**CITY OF ALBUQUERQUE
PLANNING DEPARTMENT
Development Review Board
May 26, 2004 Comments**

PROJECT # 1003449 APPLICATION # 04-00765

RE: Tract 42, Town of Atrisco Grant, Unit 2/sketch

DEVELOPMENT REVIEW BOARD--SPEED MEMO

SKETCH PLAT

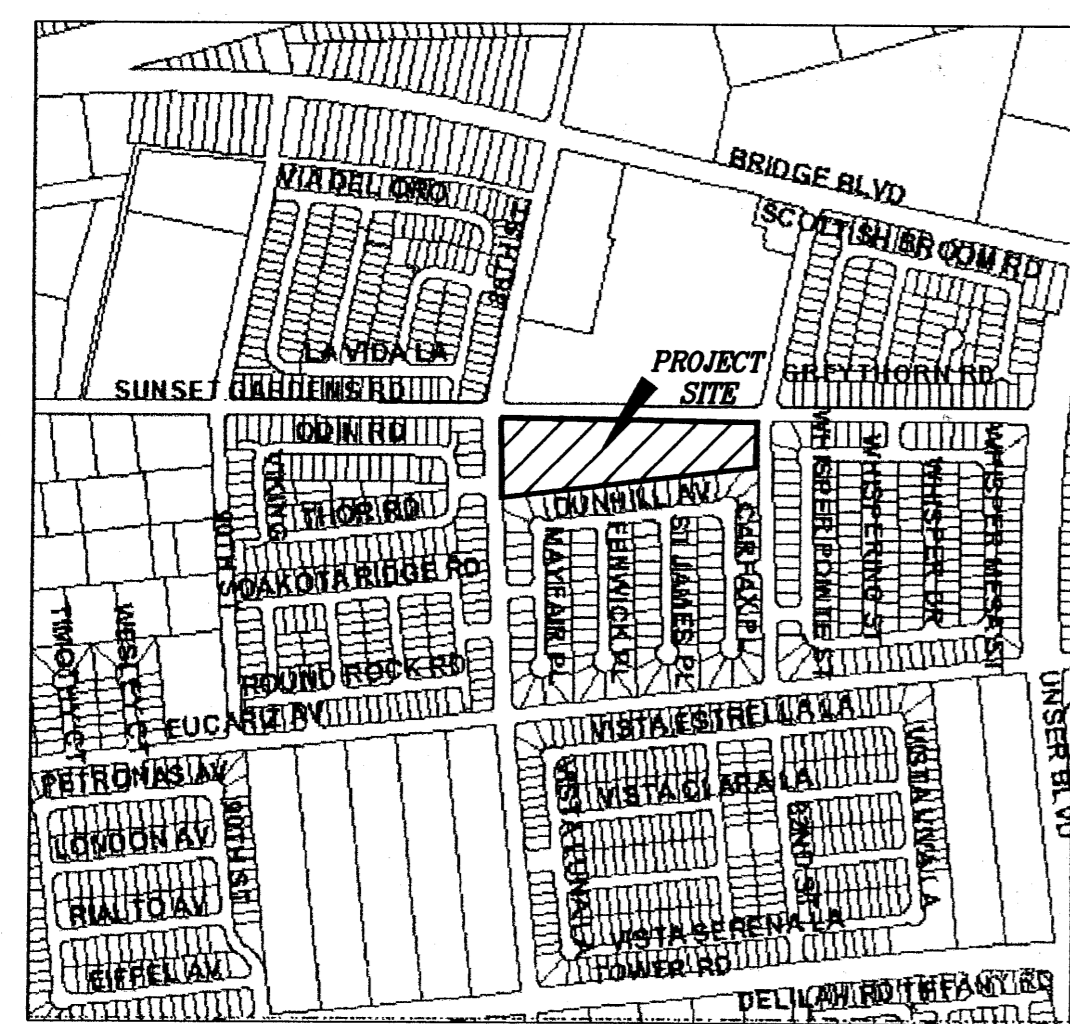
This property lies within the Tower Unser Sector Plan boundaries. Please be sure to consult this sector plan as development plans proceed.

If there are any perimeter walls to be built along the streets, a wall design submittal is required with preliminary plat submittal.

An approved drainage report is required for Preliminary Plat approval.
An approved infrastructure list is required for Preliminary Plat approval.

The R-D zone requires 2,400 square feet of open space for each dwelling unit. With submittal of the Preliminary Plat/Site Development Plan, provide an Open Space Calculation Table showing the lot number, lot size, building & driveway area, provided open space, remaining open space requirement (this table can be separate from the plat itself). Provide a dimensioned Typical Lot Plan, which shows a typical lot with the building footprint and driveway (this should be on the Site Development Plan rather than the plat). Include one of the following notes on the Preliminary and Final Plats indicating how the total remaining open space requirement will be met:
